# Consultee Comment for planning application 23/03073/HYBRID

| <b>Location</b>           | <input type="text" value="Phase 2 SW Bicester Kingsmere Parcel R East Of Ludlow Road Bicester"/>   |
| <b>Organisation</b>       | <input type="text" value="Drainage (CDC)"/>  |

SECTION 104 ADOPTED DRAINAGE GA

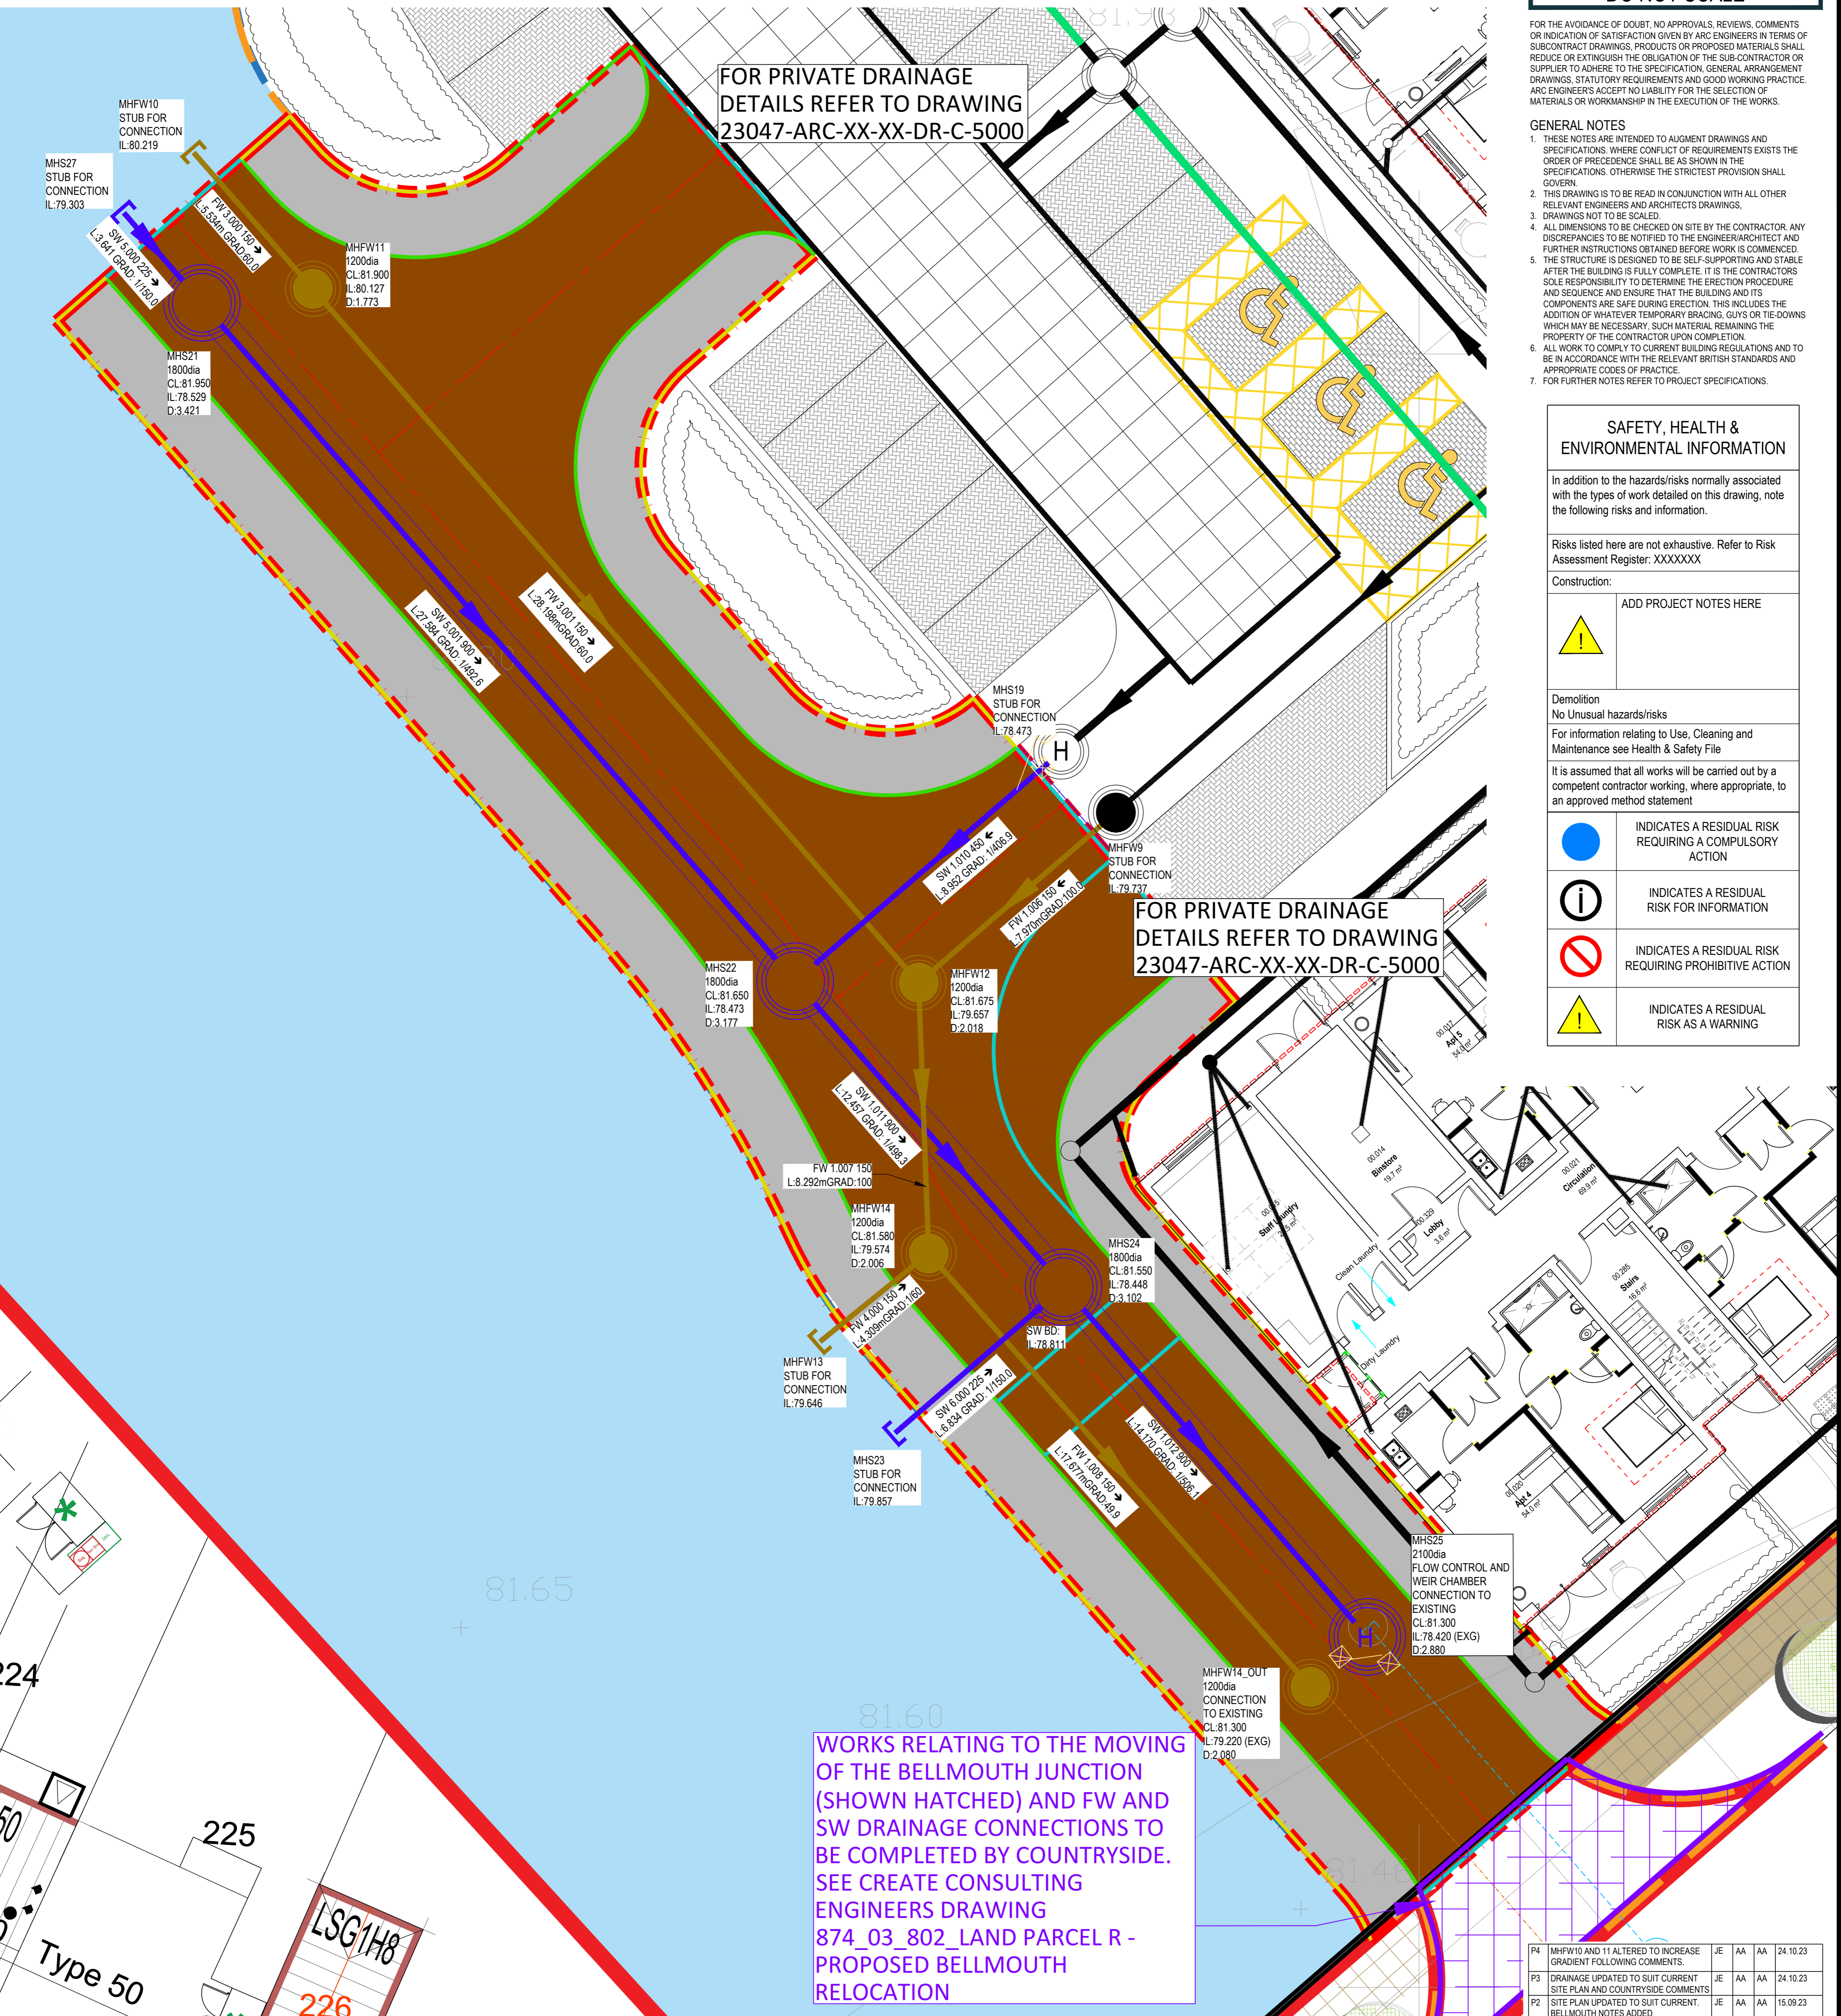
| <b>Comments</b>           | <input type="text" value="No comments on the foul drainage strategy which is essentially a Utility matter for Thames Water. The S.104 agreement will ensure that the adoptable sewers to which the site will discharge, and any already adopted sewers downstream, all have the required residual capacity.&lt;br/&gt;&lt;br/&gt;Please ask the Drainage Consultant to contact me on two points of detail about the surface water drainage strategy to clarify the philosophy. In section 3.4 of the Drainage Strategy document it states that the Parcel R discharge will be limited to 3.5 l/s up to the 10% AEP event but there will be a free discharge for more severe events. Similarly, the Extra Care site discharge will be 2.0 l/s up to the 10% AEP event but there will be a free discharge for more severe events."/> |
